PLANNING AMENDMENT

BARN CONVERSION

**CONDITION COMPLIANCE APPLICATIONS H06/0869/96 & H06/0870/96
DETAILS OF DOOR AND WINDOW SCHEDULE, BARN CONVERSION,
LAND OFF BLAZE GATE, GEDNEY - DGM PROPERTIES LTD.**

CONDITION COMPLIANCE APPLICATIONS H06/0869/96 AND H06/0870/96
DETAILS OF DOOR AND WINDOW SCHEDULE, BARN CONVERSION, LAND OFF
BLAZEGATE, GEDNEY - DGM PROPERTIES LTD.

DRAWING No.
DGM-G 2/6

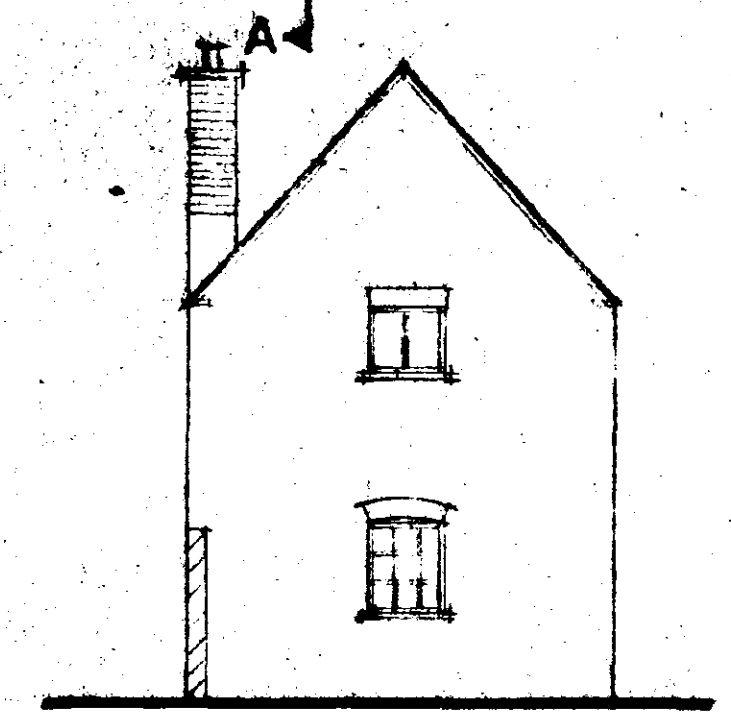
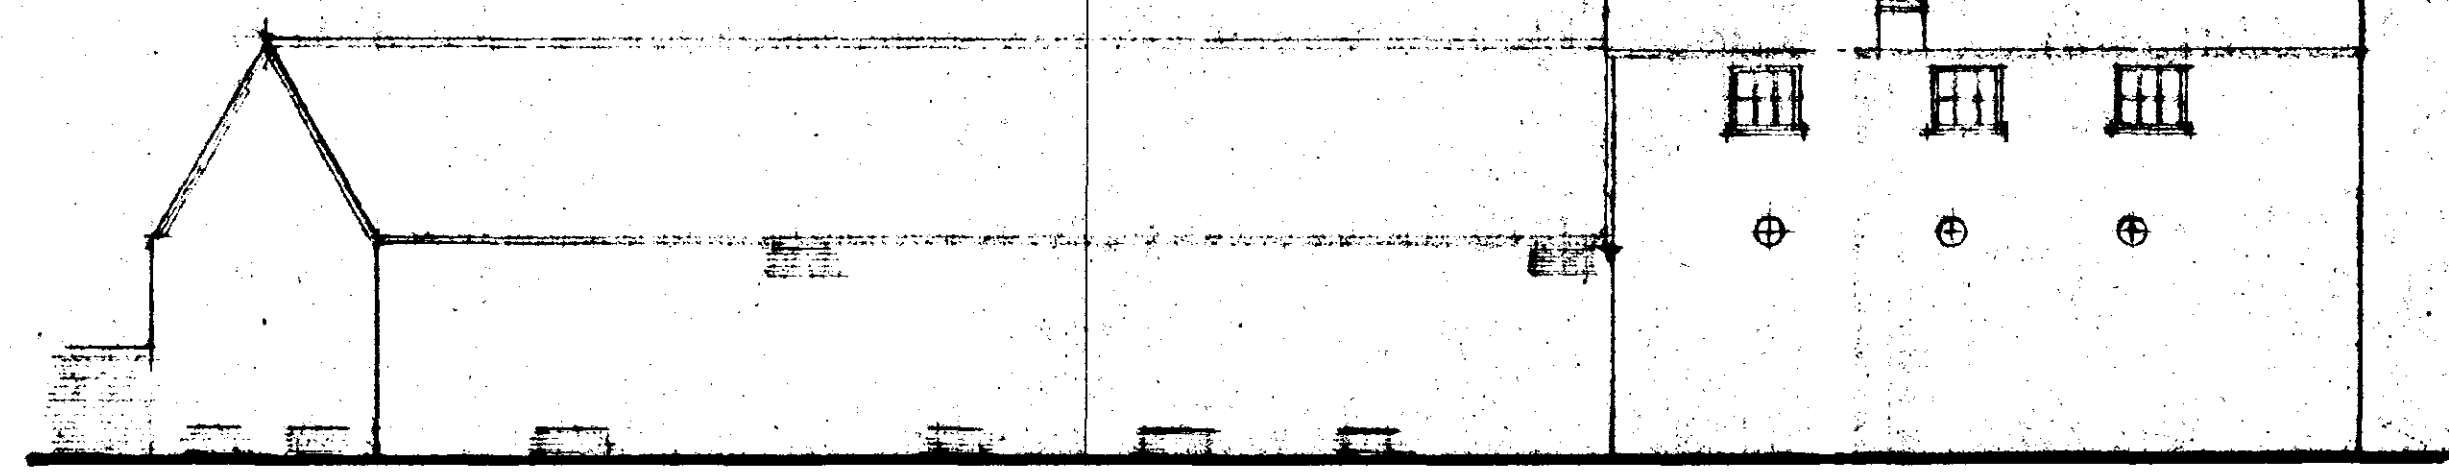
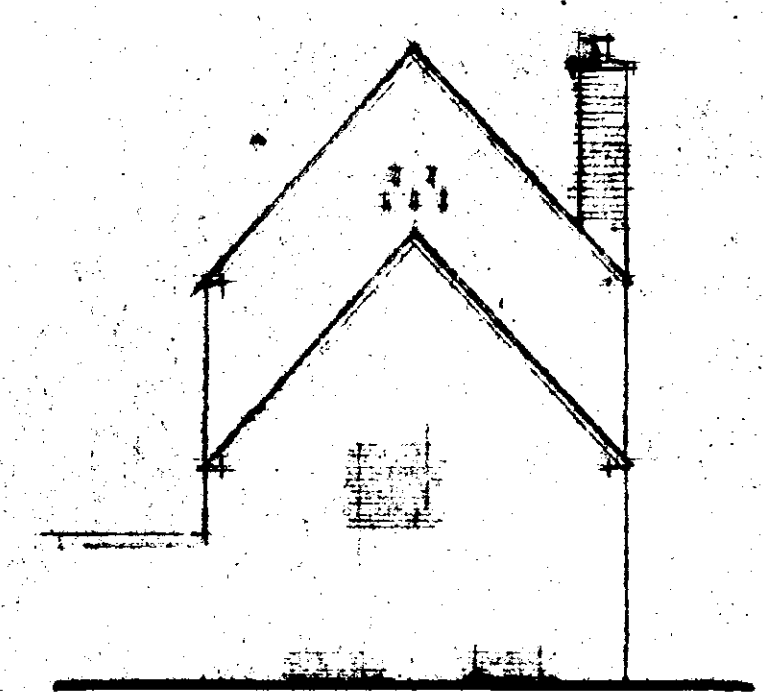
Additionally, can you please confirm that the bonding of the brickwork and also the mortar will match that existing as closely as possible.

- 1 The bonding of the brickwork and also the mortar will match the existing as closely as possible.
- 2 The windows need to have full opening lights to comply with Building Regulations on ventilation areas, my clients agree to all windows being side hung. Incidentally some of the existing windows are pivoted from the centre.

DRAWING No.:
DGM-G 2711-X

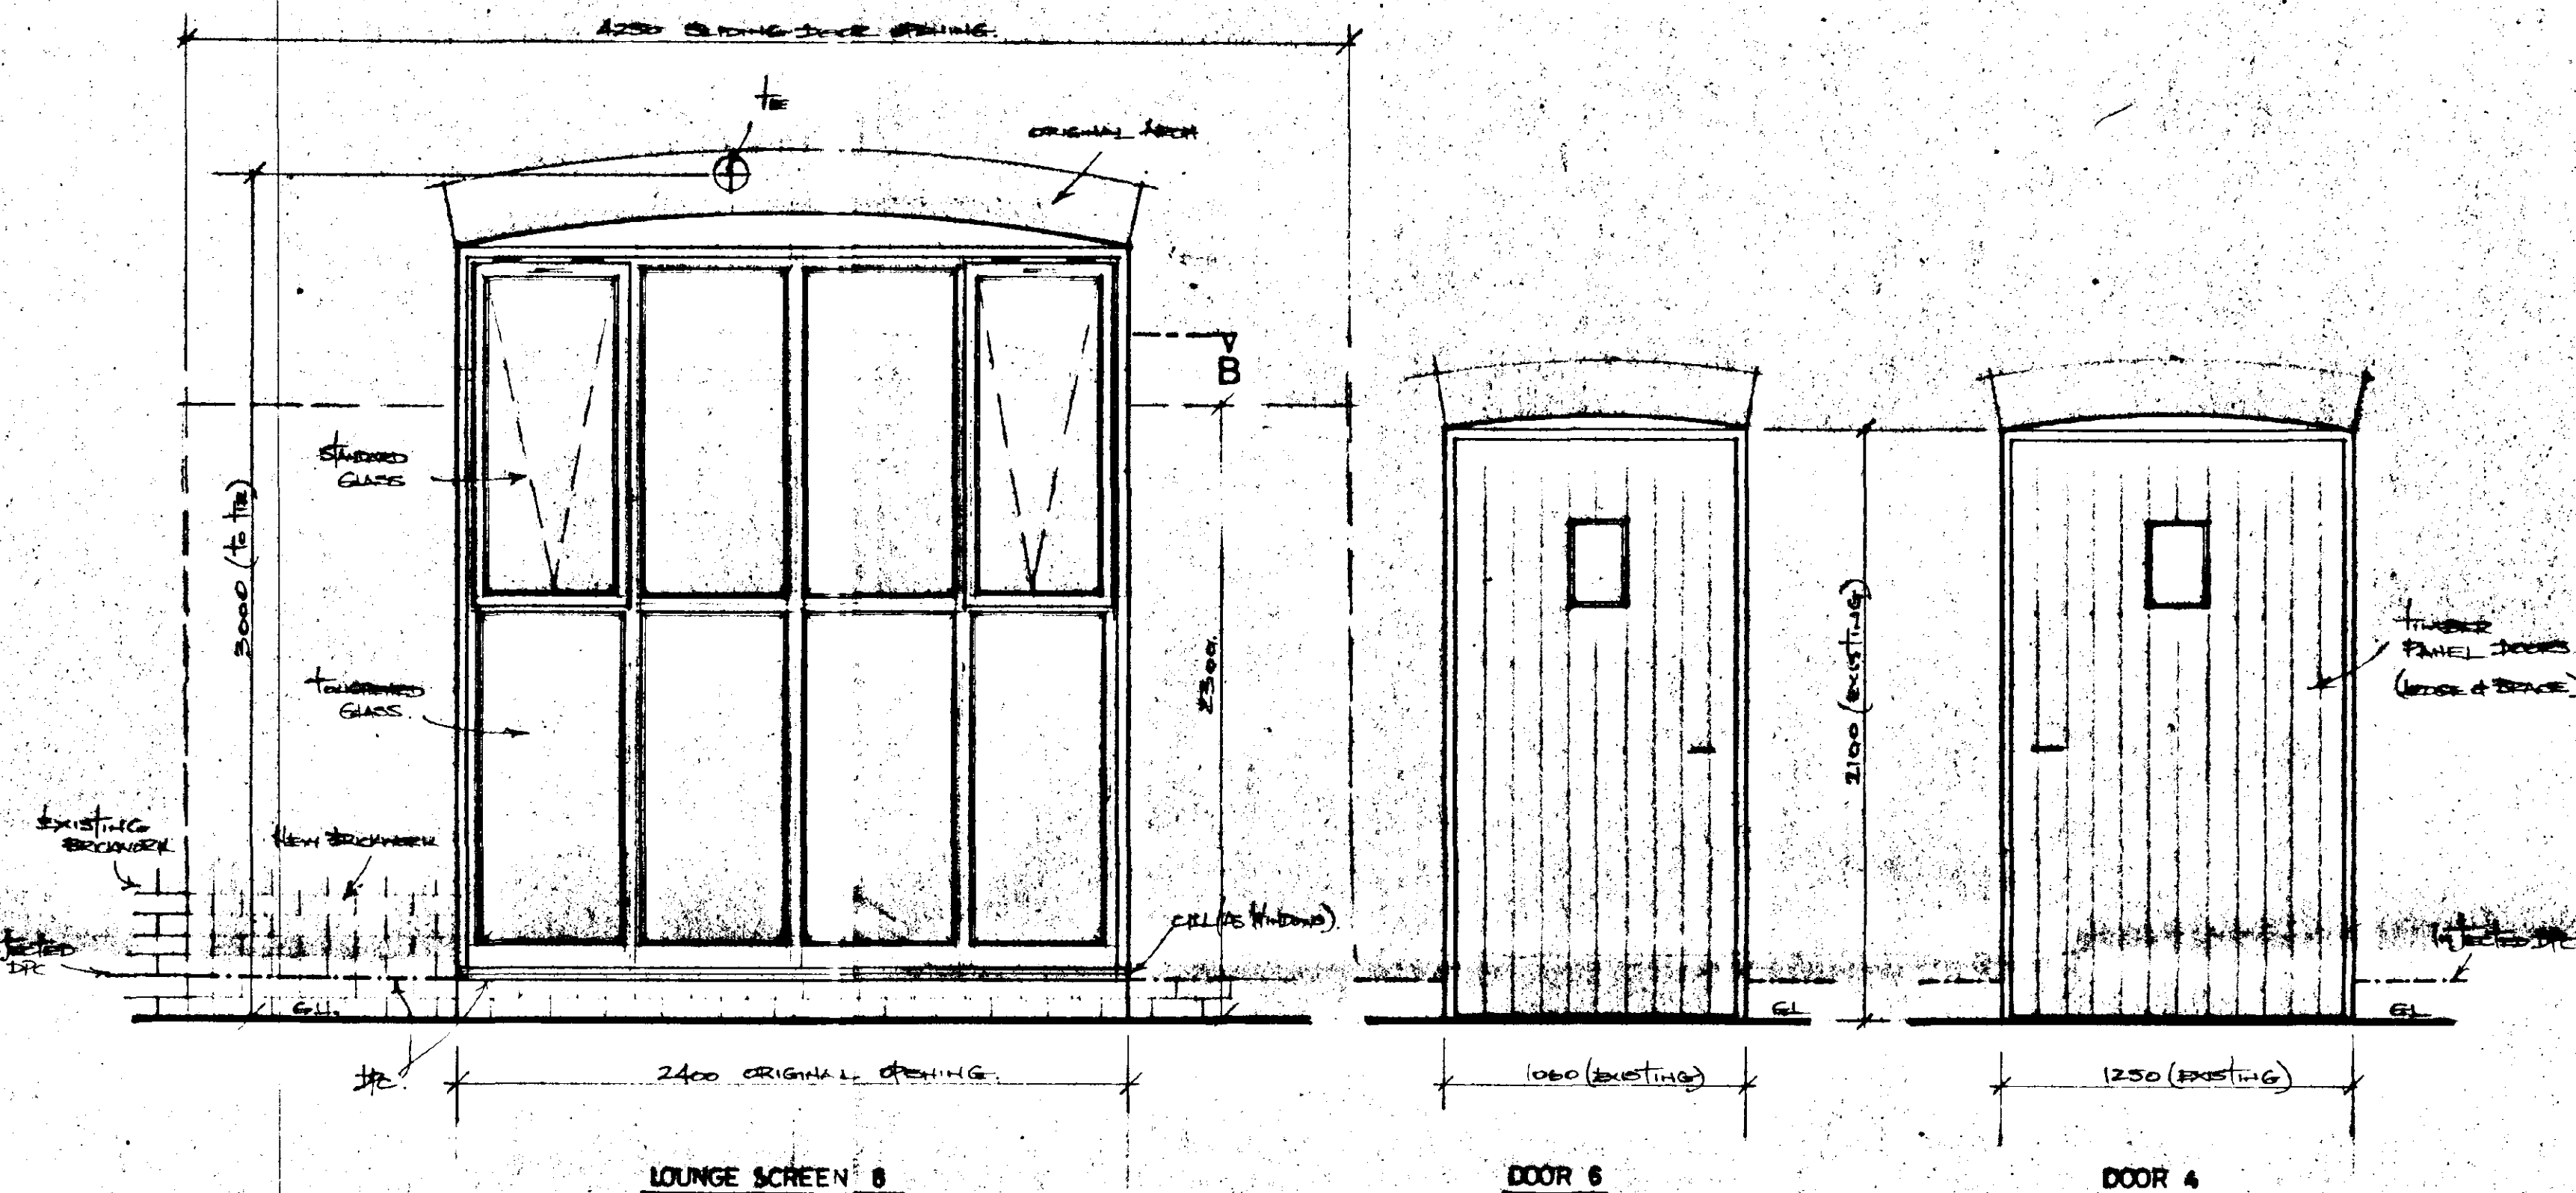
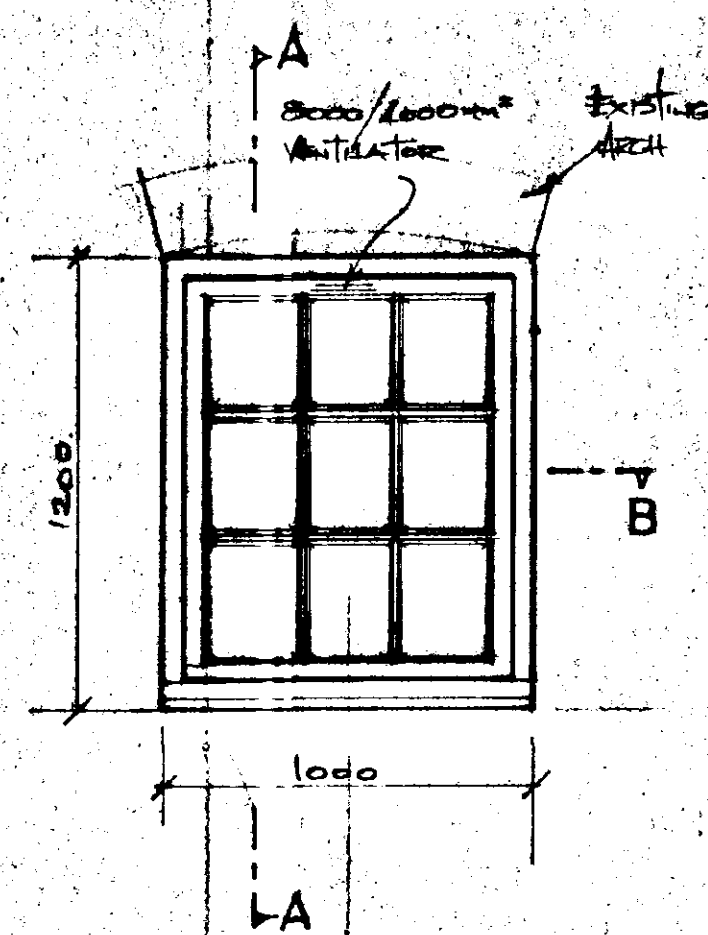
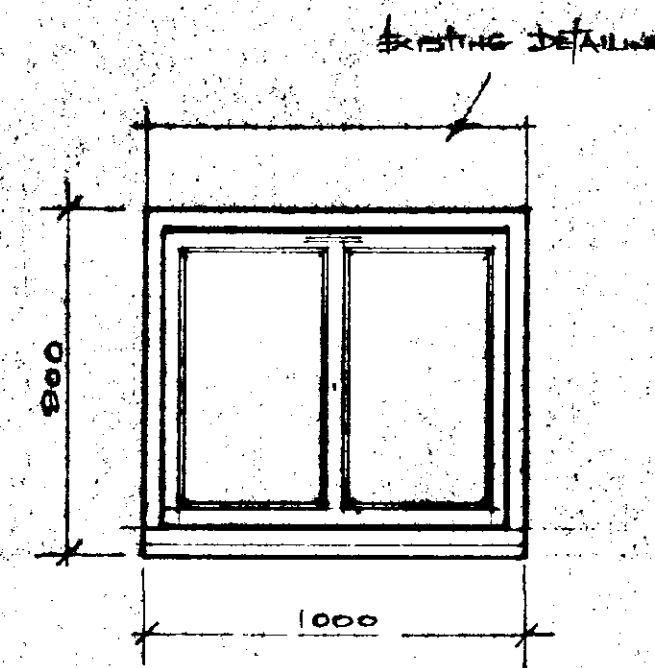
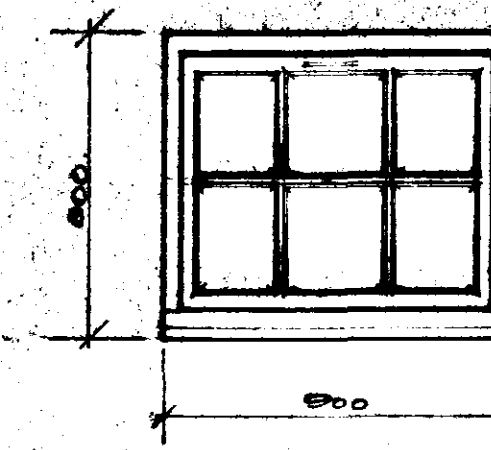
Firstly, it is noted that the windows are to be top hung. This is considered inappropriate in a traditional building such as this and side hung windows would be more preferable.

- i) Please confirm that the windows are of timber construction.
- ii) Details of the construction (including materials) of the doors and new window within the existing arched opening.
- iii) Details of the new brickwork, including bonding, how it is to be tied in with the existing and type of mortar.

Further to my letter of the 1 November and subsequent discussions with my clients and your Mr Gedney it makes sense to have all windows top hung openings as detailed on the plans as all existing first floor windows are top hung, many of the existing ground floor windows; strange as it may seem; are pivoted from the centre.
